**To:** FILE  
**From:** Caitlin Cameron  
**Subject:** Application ID: 2014-066  
**Date:** 6/2/2014

Re: PEZ.2014.-066, Block/Lot #20-F-23, 185 Fore Street

Memo To: Caitlin Cameron  
Barbara Barhydt  
From: David Margolis-Pineo  
Re: 167 Fore Street – Review Comments 2014-066  
Department of Public Services

(F) BARRIER FREE RAMP DETAILS
N.T.S.

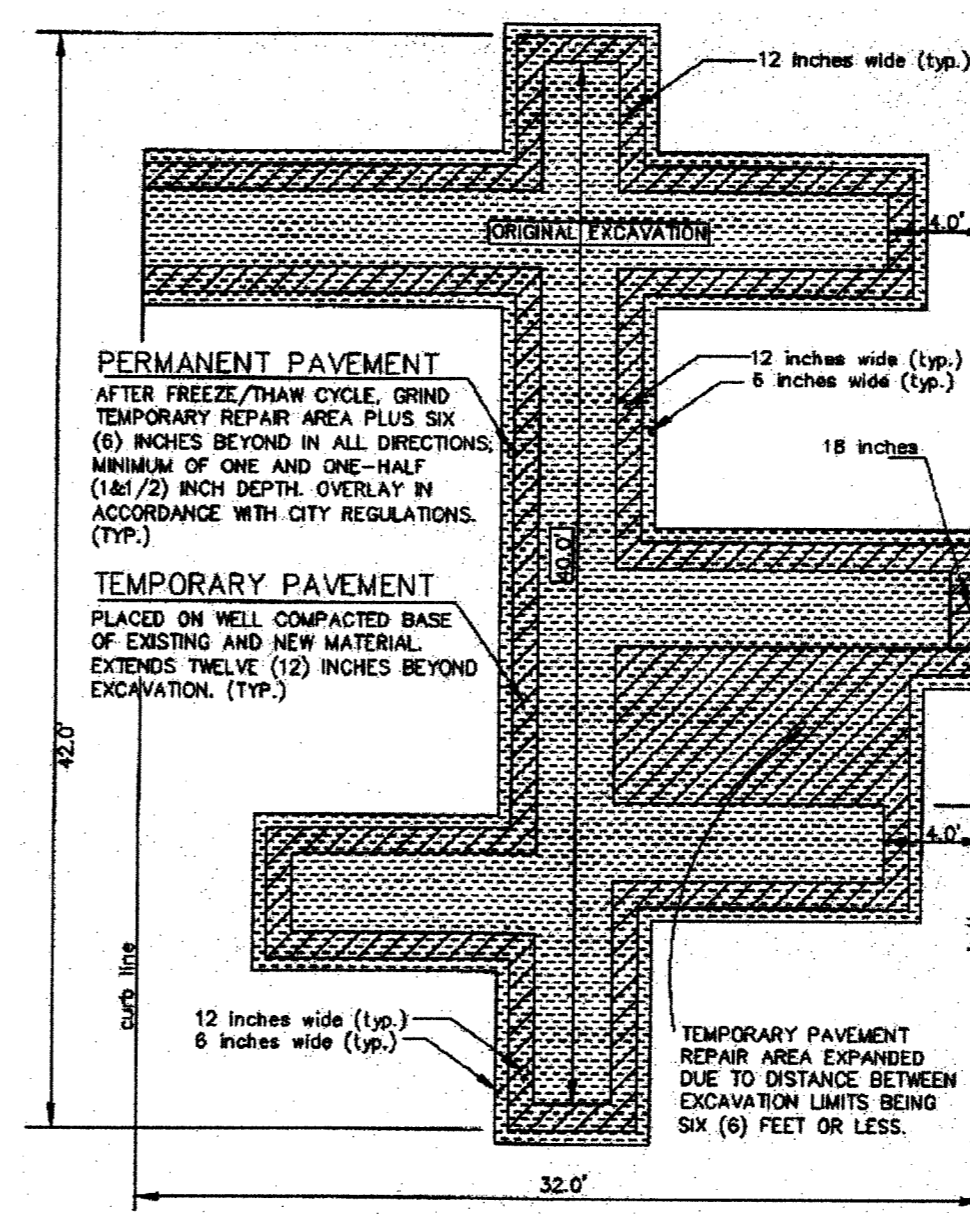
Curb ramps must be designed in detail showing the dimensions of tipdown curbs, flush curb and dimensions of detectable warning panels. Also show the location of any drainage structures and utilities that may impact curb ramp location and design.

(K) BIKE HITCH MOUNTING DETAIL
N.T.S.

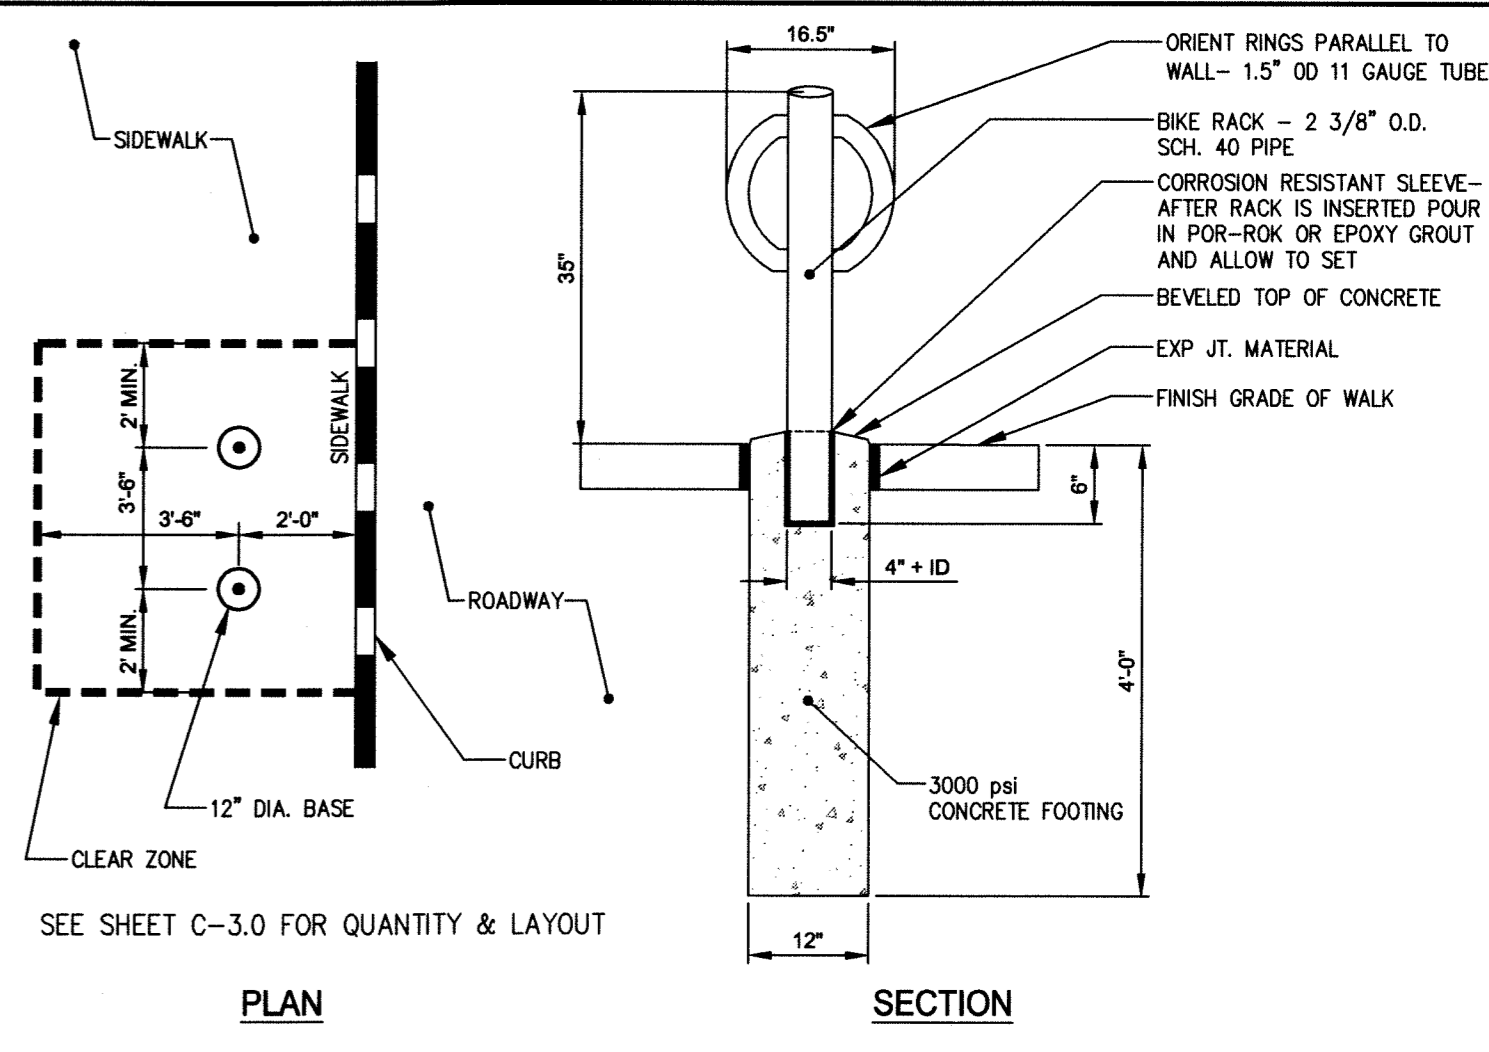
5. The applicant is requested to place additional bike parking on Fore St in the proximity to office/retail door and to locate towards the back of the sidewalk and away from the curb line.  
Bike rack spacing guidelines:

- If bike racks are located next to and parallel to the building, they shall be a minimum of 30" from the building (36" preferred). The minimum spacing between racks (on center) shall be 6'.

- If bike racks are located next to and perpendicular to the building, they shall be a minimum of 48" (on center) from the building (60" preferred). The minimum spacing between racks (on center) shall be 36" (48" preferred).

- If bike racks are placed at the curb and parallel to the curb, they shall be located a minimum of 24" from the back of curb (36" preferred). The minimum spacing between racks (on center) shall be 6'. They should be placed/spaced to avoid car doors opening based upon expected parking spacing.Bike racks may not be placed when bicycles are parked to reduce the clear sidewalk width below 5'.
